comments on CMP for D Street/Valley Street/St. John work this summer

Attached are our comments on the construction management plan and design for the 3" mountable curb at D Street. A couple of additional comments from me:

PHASE 2 LOGISTICS PLAN SUMMER 2019 - DECEMBER 2019

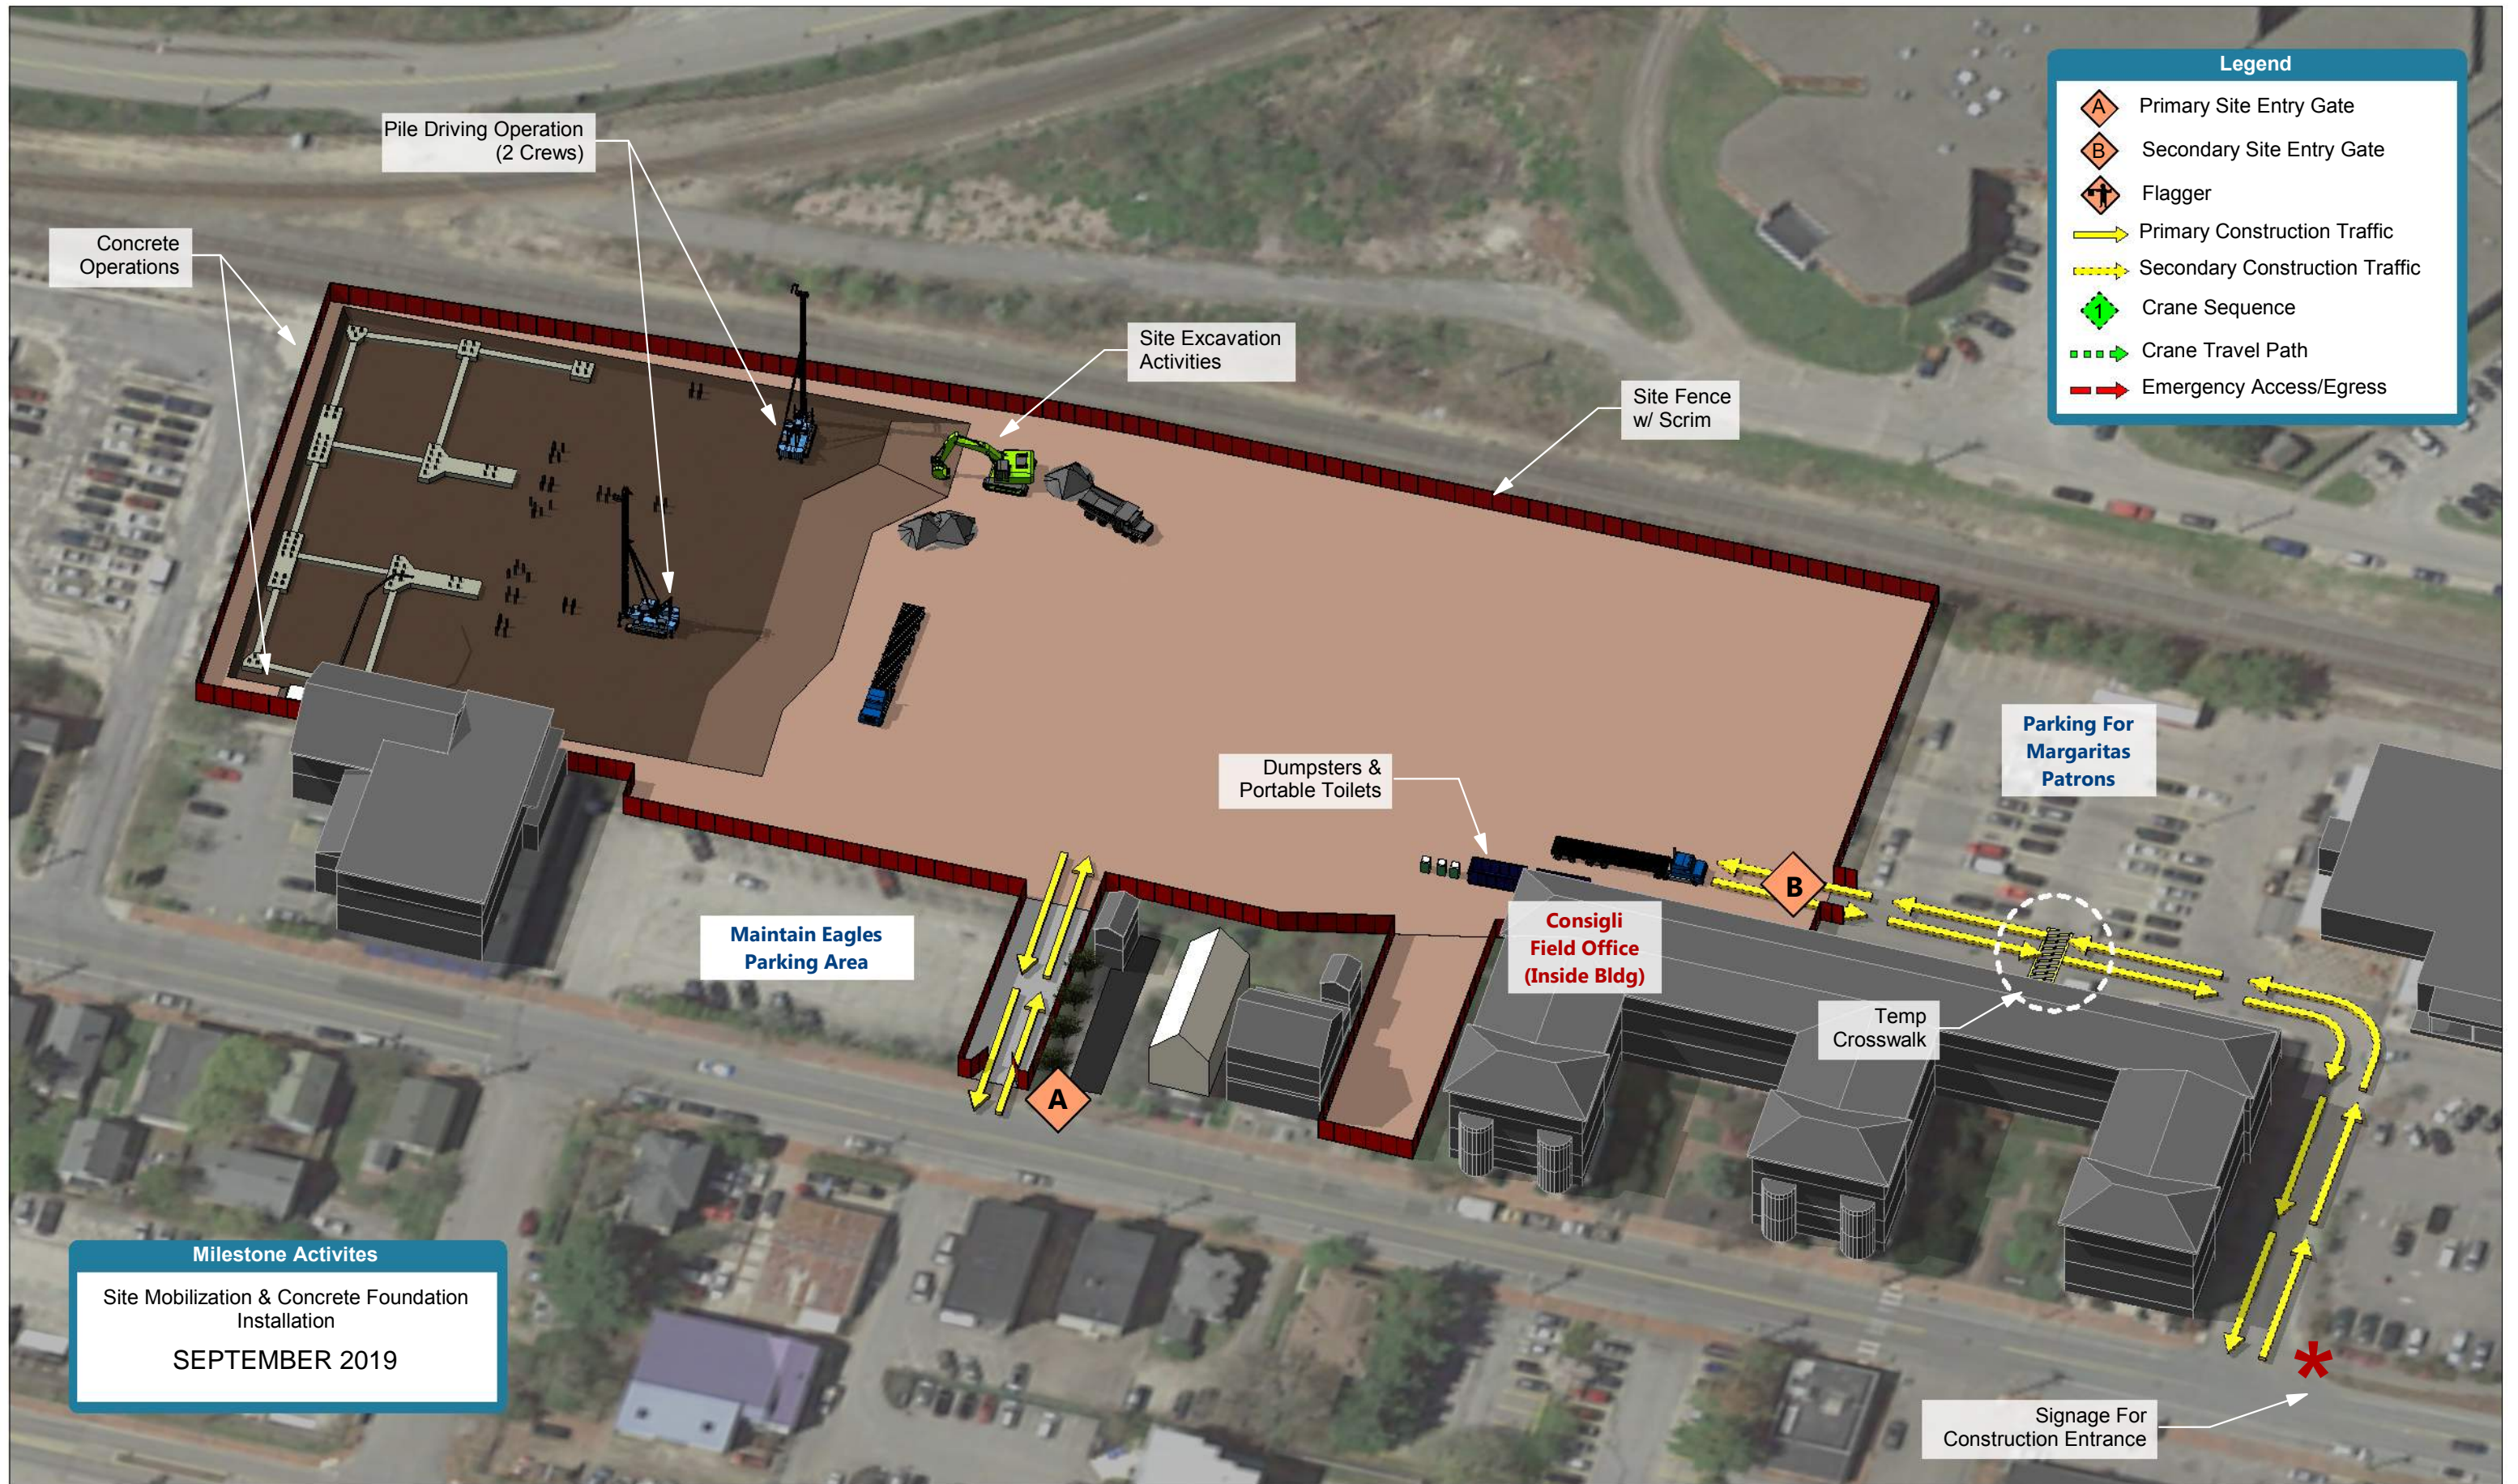
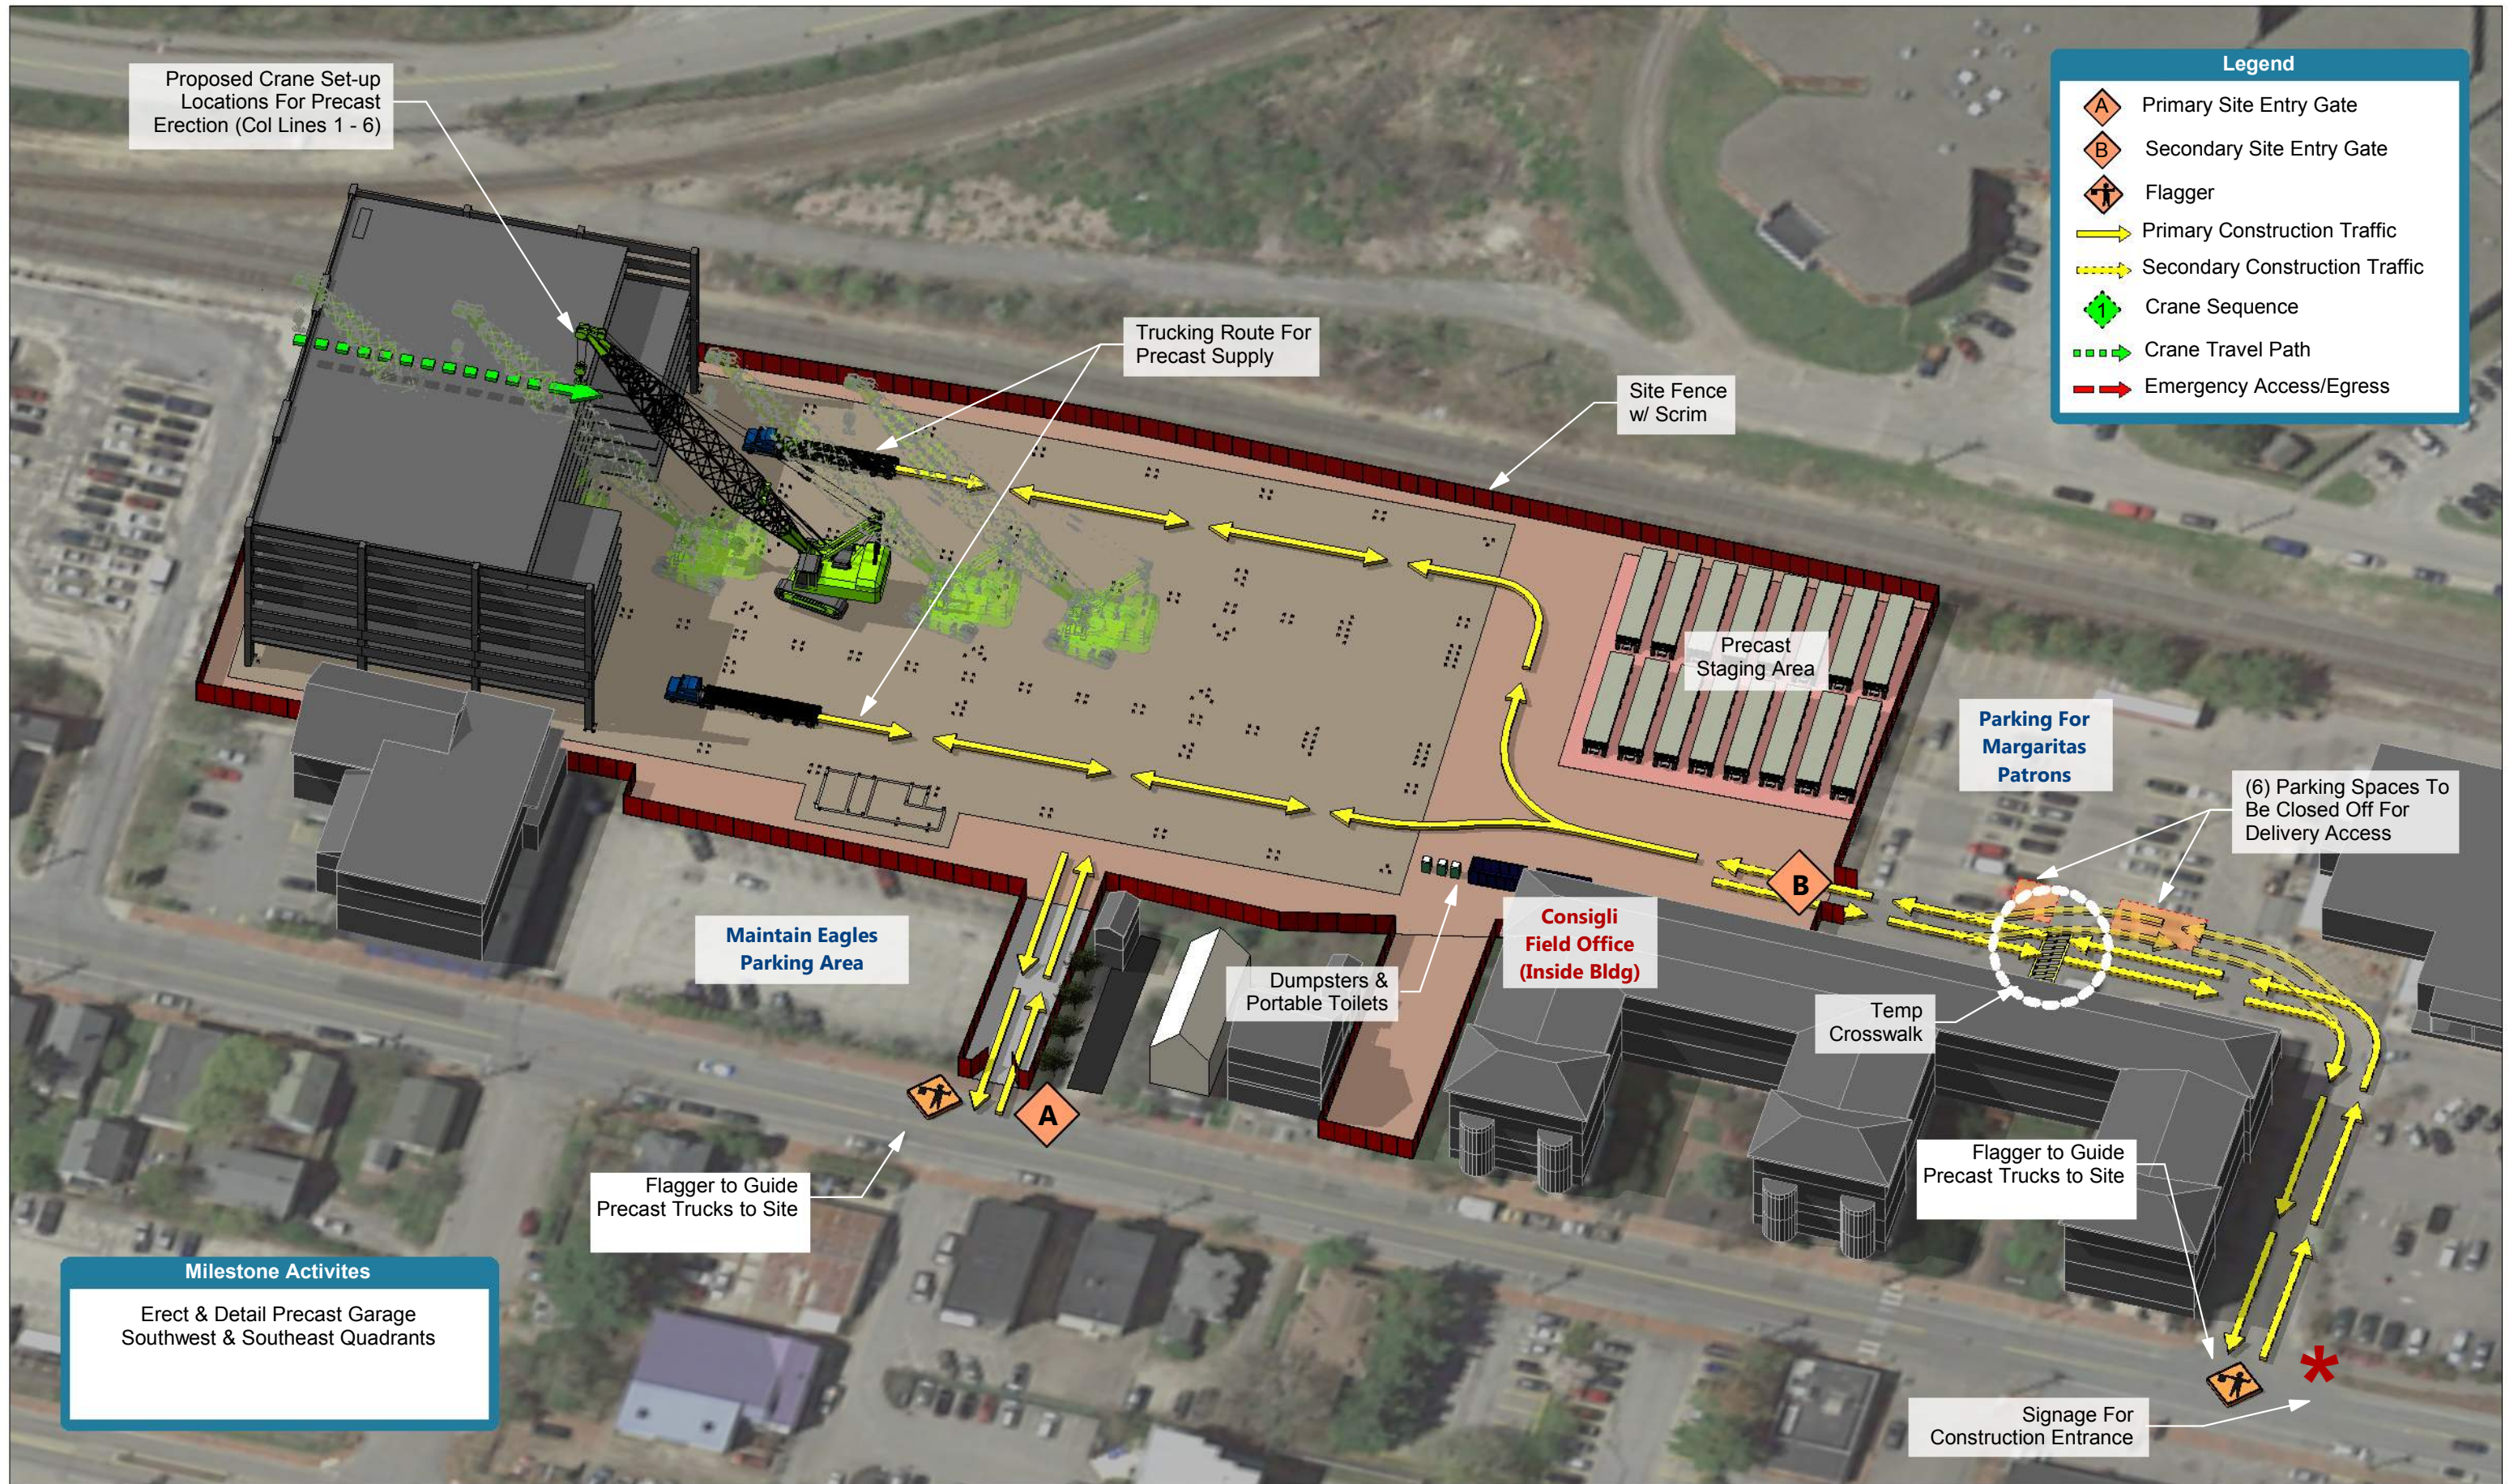
- Can you add some language into the narrative to cover the plan for working with neighbors on D Street, particularly Moldaver, where the fence will be relocated and plantings need to be coordinated, and Prosser, whose curb cut will be affected (and where the grading will be required). I know that Al and Walter have been thinking about this, but I just want to make sure that the plan is on the record.
- These neighbors are also very concerned about loss of on-street parking spaces, as you're aware. Anything we can do to minimize the loss of on-street spaces in this area would be great.

To expand on the parking portion of this, we have included the number of spaces that will be needed as we cross St. John St with the utilities. As far as minimizing the impact the best we can hope to accomplish is to complete the work earlier than expected. Right now we are anticipating four weeks that these parking spaces will be required.

Attached is the revised narrative to address the parking and the neighborhood communications.
